Bath Savings Branch Bank

**CITY OF PORTLAND, MAINE
DEVELOPMENT REVIEW APPLICATION
PLANNING DEPARTMENT PROCESSING FORM**

RE: Bath Savings Institution, 40-42 Auburn Street
Application ID #2003-0029, CBL #375-A-002

Re: Branch Bank, 40-42 Auburn Street, Bath Savings Institution, Applicant

SITE LAYOUT PLAN

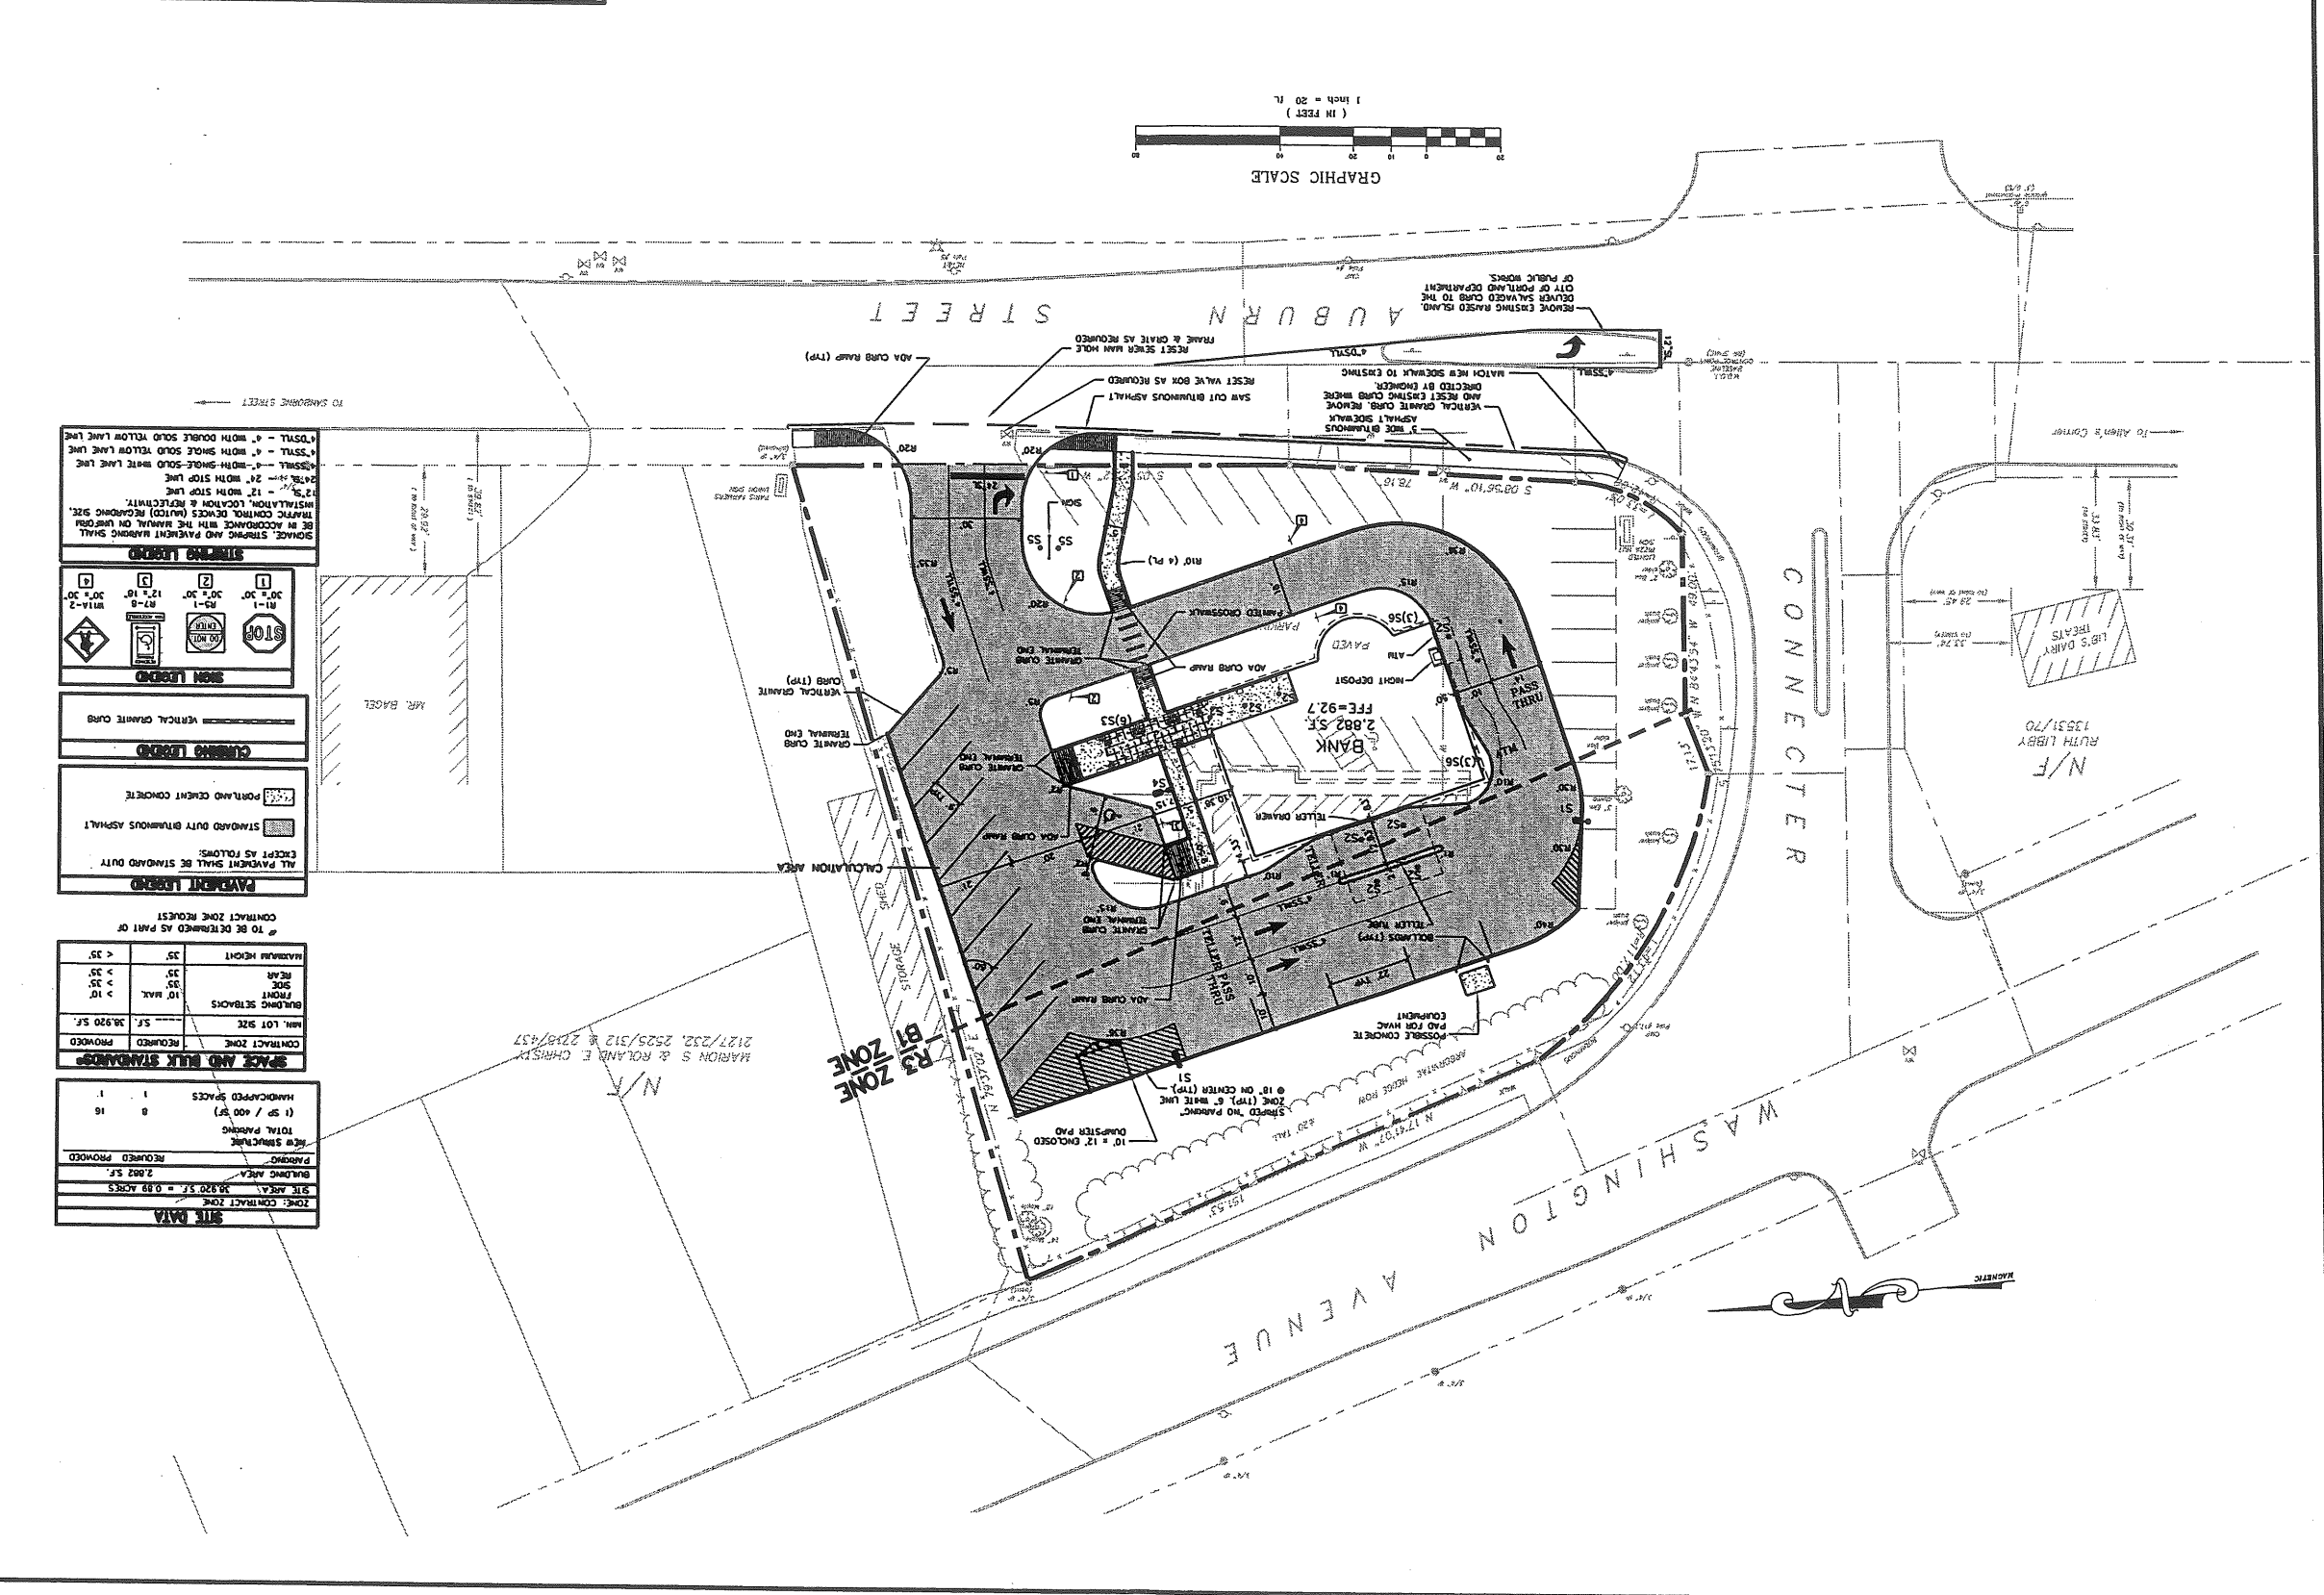
3. That the applicant revise the site plan to include a 5-foot esplanade from where the esplanade ends at Washington Avenue along the frontage to the northeasterly corner where the property ends to generally follow the existing esplanade on Washington Avenue. A pedestrian easment shall also be submitted for staff review and approval.

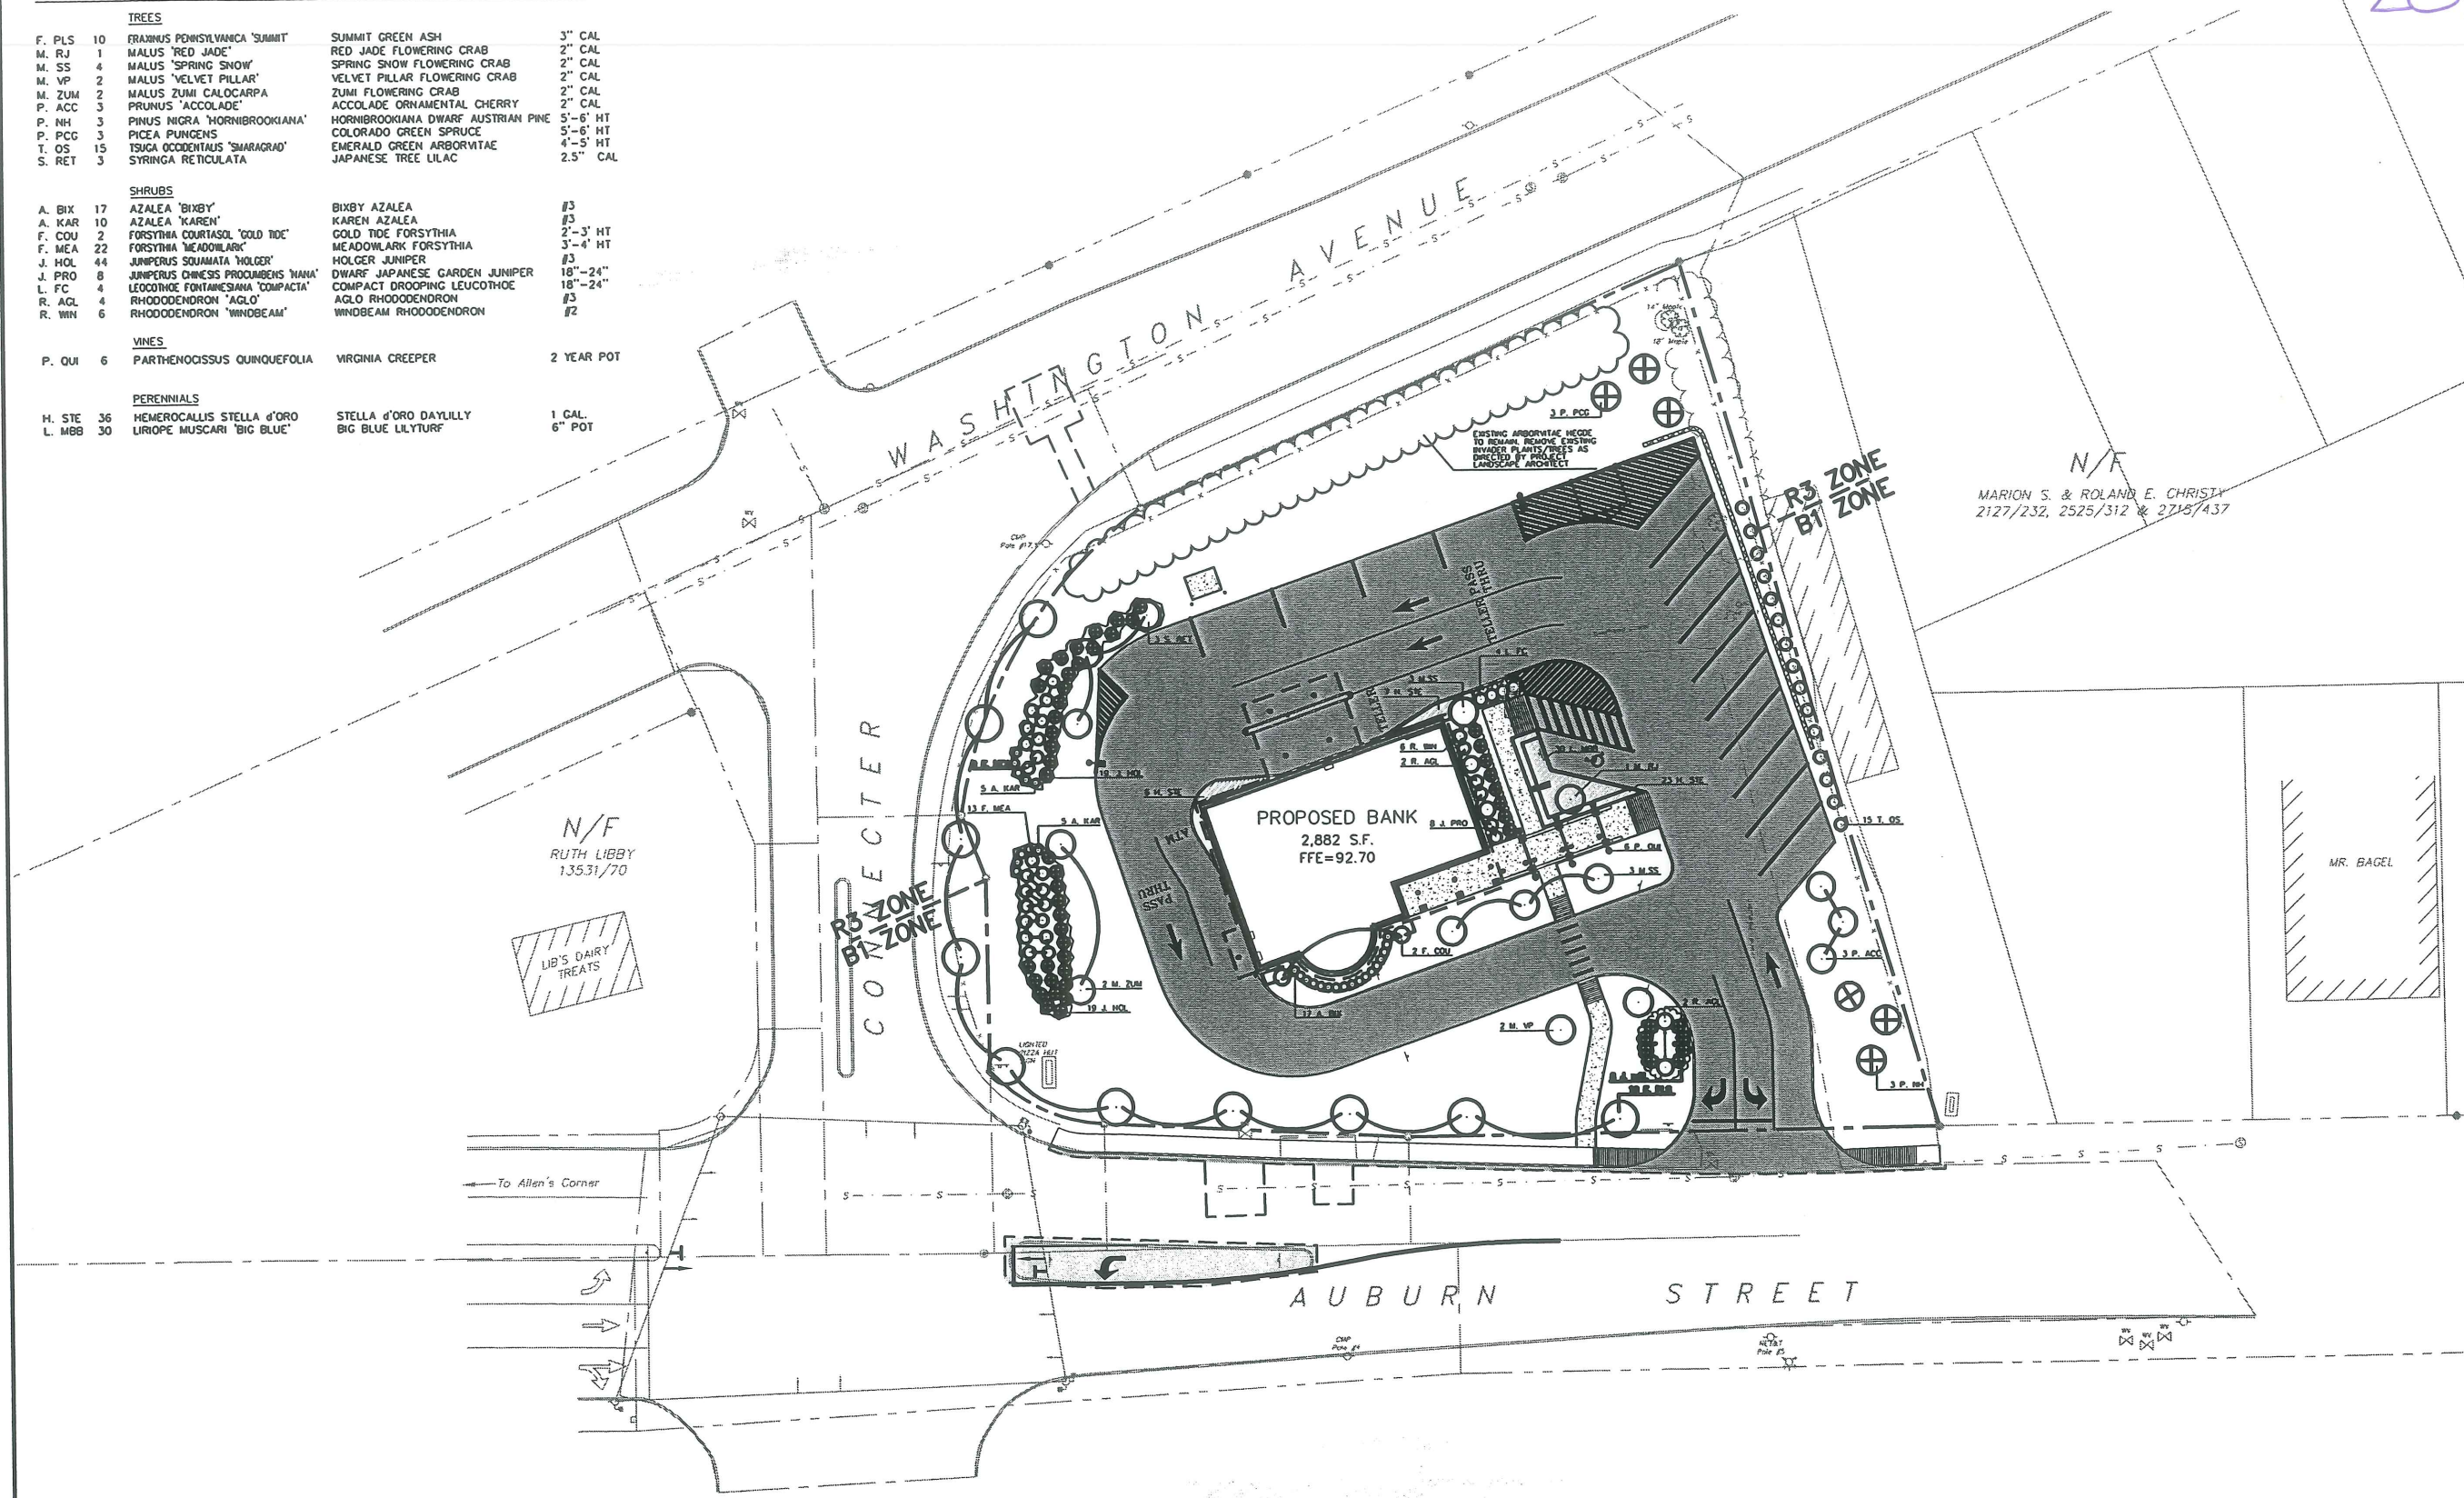
1. That the applicant revise the landscaping plan to change the tree specie from Colorado Green Spruce to either Serbian Spruce or Norway Spruce.
